SSDA 6471 - SYDNEY MODERN

Submission in Response to SM Addendum 8/8/2018

Dated 23 August 2018

Steensen Varming in Proposed Plan Appendix H (Job: 14702 can020, 2018-03-16)

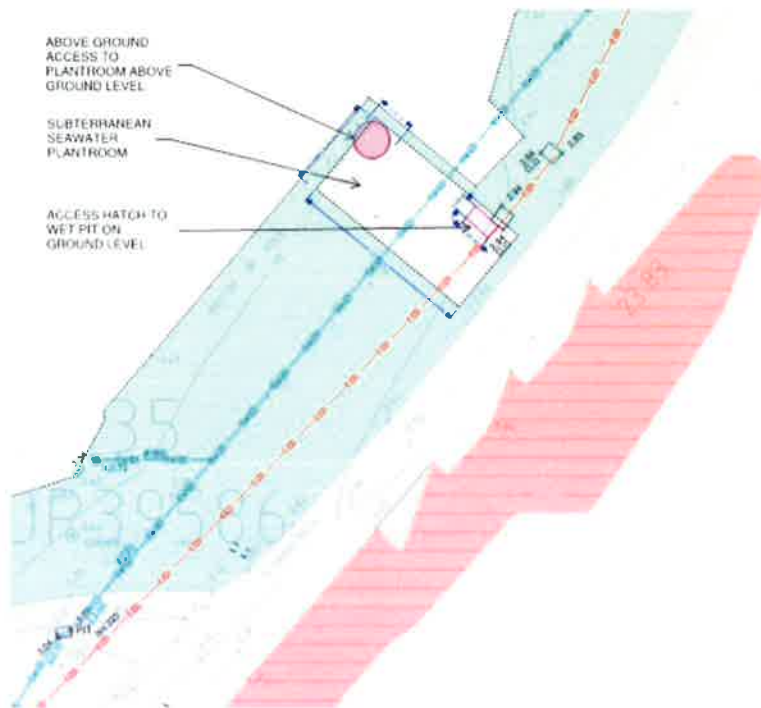
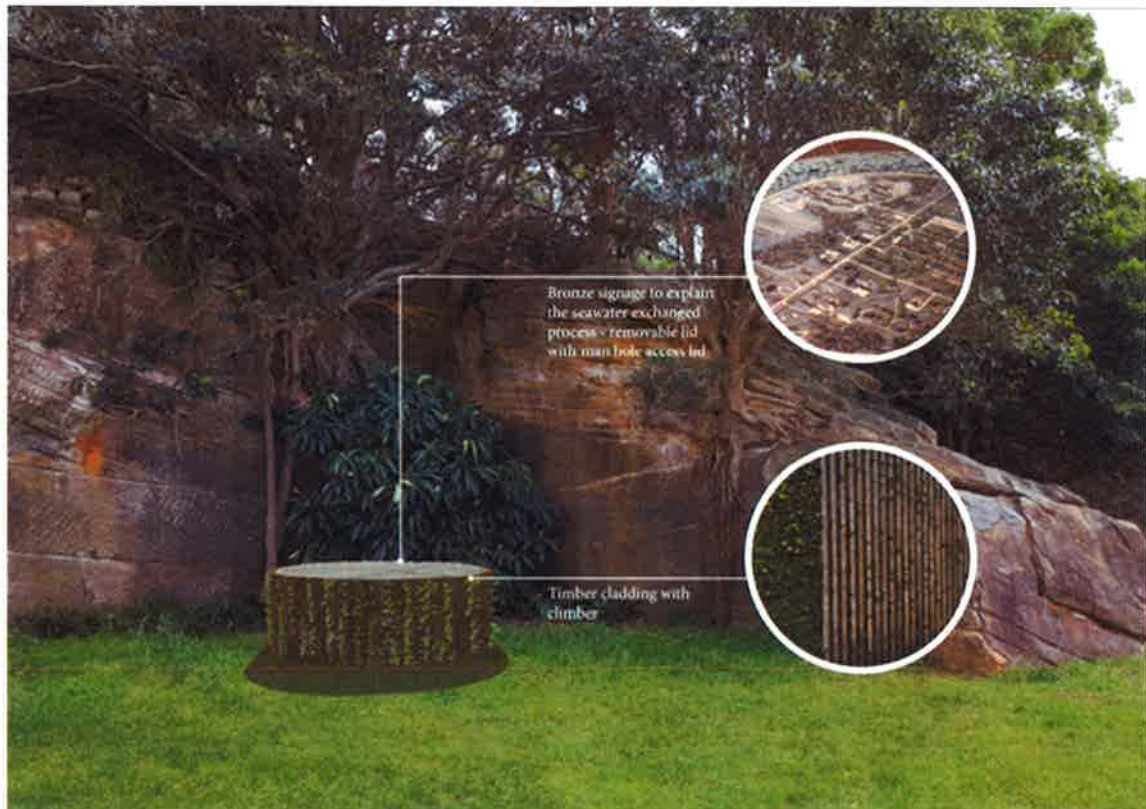
This is the first time SM has supplied enough details of the SWEC to permit any form of assessment , still not enough.. Arup does not deal with the ventilation shaft (exhaust) function emitting air (noise and vibration) from the pumps and fans. Arup does not address the turbine effect (noise and vibration) of the Penstock Valve exhausting water through 2 x 400mm pipes when intakes are via 2 x 1200mm pipes.

I attach a series of photographs , showing with the white bucket, the SM proposed ventilation shaft location and with the red bucket showing my proposed location of the ventilation shaft 30m to the south. Refer Photo 3

The location proposed by SM in a pristine rock corner of the RBGD with fig trees climbing up and down the rock face will destroy that HERITAGE AREA. Refer SM's SSDA submission on the heritage value of this rock wall and RBG area. Refer Photo 4

The location proposed by me , approx. 30 metres to the south is surrounded by a degraded rock face and bridge structure more consistent/compatible to the industrial SWEC chamber with ventilation shaft. Refer Photo 5.

The SM proposed ventilation turret will be less than 15 metres from my bedroom windows (opening for ventilation and cooling) not 19 metres as claimed by Arup. Do they need a tape measure?

The SWEC location as proposed by me has NO residential windows within 40 metres. Refer Photo 6

I request that the SWEC be moved 30 metres to the south. There are no cost implications to SM.

- 1 SM provide full acoustic details for amelioration of noise/vibration emanating from the Ventilation Shaft from the fans , pumps and Penstock valve.
- 2 The SWEC be moved 30 metres to the south.
